From: Fen Drayton Parish Council,
c/o Gill Parrish,
PO Box 1102
Fen Drayton,
Cambridge
CB24 4WZ

Your Reference: TR010018
Our reference: A14-AFP064
Representation Id No: 10031014

June 15 201 - Update of our Representation to the Planning Inspectorate with regard to the A14 Cambridge to Huntingdon Improvement Scheme

Drawing title: **RIGHTS OF WAY & ACCESS PLANS REGULATIONS 5(2)(k) & 5(2)(c) SHEET 25 OF 28**

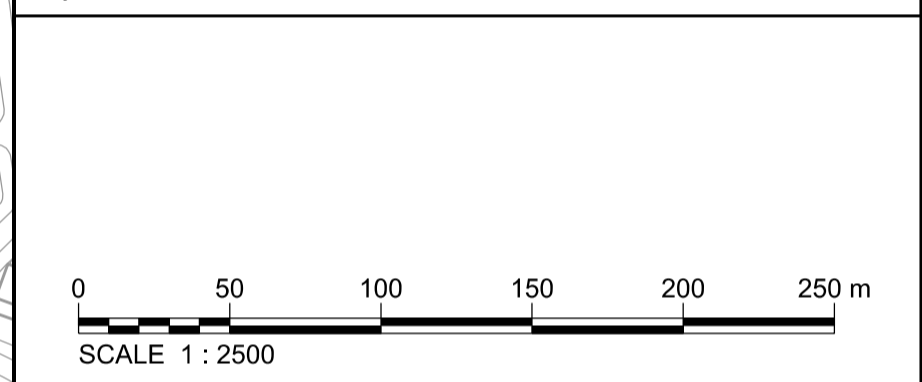
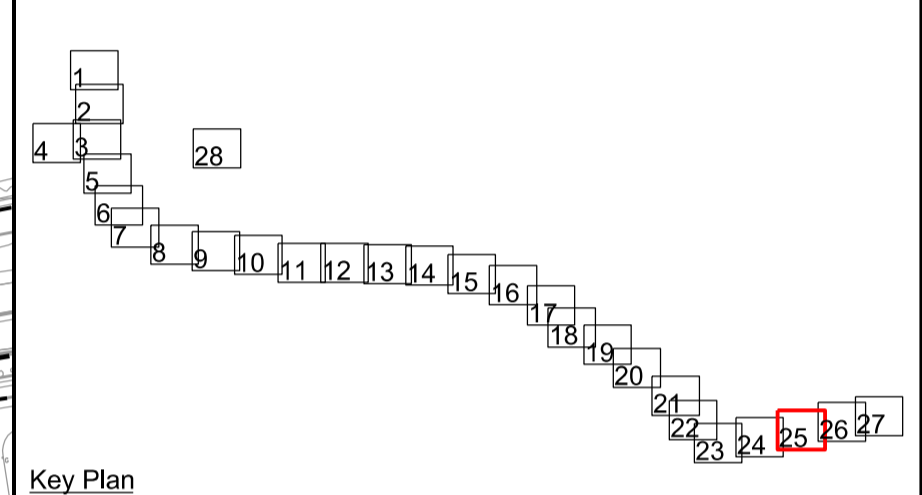
There is an existing concrete apron and access to a field adjoining the current A14 which is currently rented out under a Charitable trust providing much needed income for the village. A compulsory purchase of part of this land for pedestrian and cycle access will prevent access to the field for agricultural use and diminish the viability of the field. To maintain the income from the field new access arrangements need to be put in place and managed as part of the road development. See also further information under point 8 below.

8. Access would need to be retained to the Fen Drayton Town Lands field from the A14.

The Town Lands are owned by a charitable trust whose trustees are the members from time to time of Fen Drayton Parish Council. Presently the only direct access to the Town Lands is by a concrete approach from the A14. Because such access is difficult, the land is rented to John Johnson, who gains access to farm the land by a neighbouring field. The proposed A14 improvement will stop up many field access points along the present A14. Even though the existing A14 will be de-trunked and will pass into the responsibility of the local authority, access from the de-trunked A14 to the Town Lands will be stopped up (see drawing number A14-ARP-ZZ-00-DR-Z-00316). According to the General Arrangement Sheet 13 (drawing number A14-JAC-E1-DR-Z-01013) the present access will be part of a compulsory purchase order taking 3882 m² (0.3882 ha) of land bordering the current A14. From the field to the road, the access will be cut by: a hedge; a culvert or ditch; a footpath and a cycleway, all running parallel to the A14. Land not used for these structures will be planted as grassland. The Planning Application appears to make no provision for alternative access, so it appears that it will not be possible, legally or physically, to access the Town Lands from the A14. In effect, the land will become isolated, except by passage over adjoining land. It is not clear that there is a public right of way over the neighbouring land so access via this route is facilitated by local agreement. Such agreement could be withdrawn at any time. Clearly, unless alternative access arrangements can be made, this will have a deleterious effect on both the capital value and the rental value of the land. The possible isolation of this land will significantly reduce the charitable income received by the Parish.

The need to retain access from the A14 as part of the upgrade development is essential to maintain this income for the Parish.
